Please ask for: Nicola Moore
Email: nicola.moore@arun.gov.uk
Telephone: Ext 37944
Our Ref: P/116/20/CLP
Your Ref:
Date: 17th November 2020

Lawful Development Certificate for a Proposed Use or Development

Development: Lawful development certificate for a Proposed timber framed detached garage
Location: 16 Lagoon Road Pagham PO21 4TJ

Mr. P. Barnes
16 Lagoon Road
Pagham PO21 4TJ
PROPOSED ELEVATIONS
Date; October 2020 Scale 1:100

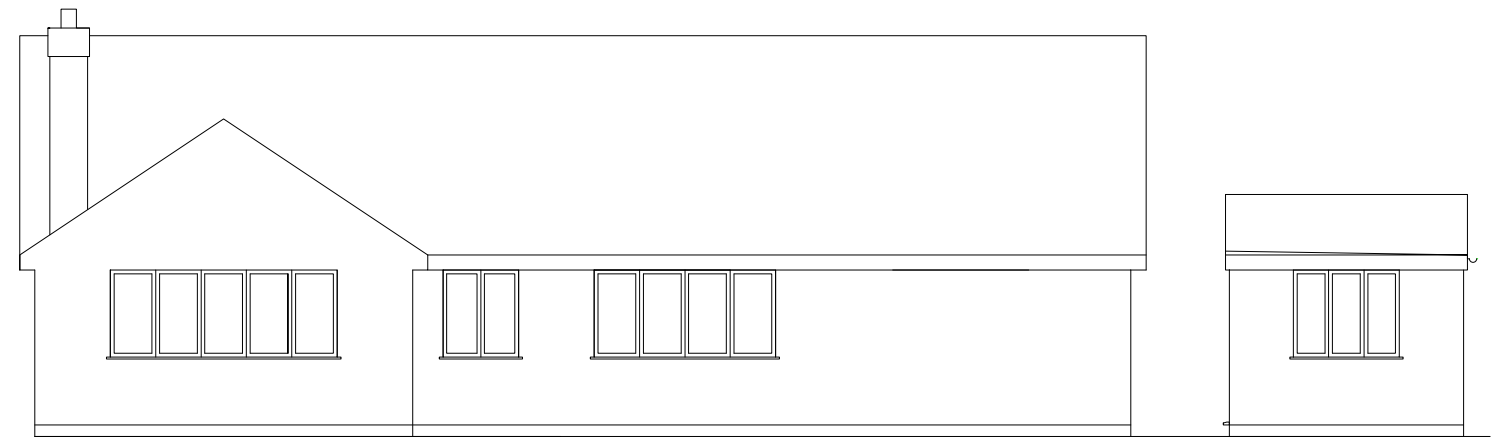
On the Proposed Floor Plan the window on the West Elevation of the Proposed garage measures 1.1m but on the Proposed West Elevation is 1.4m. Please check the measurements, amend accordingly and re submit.
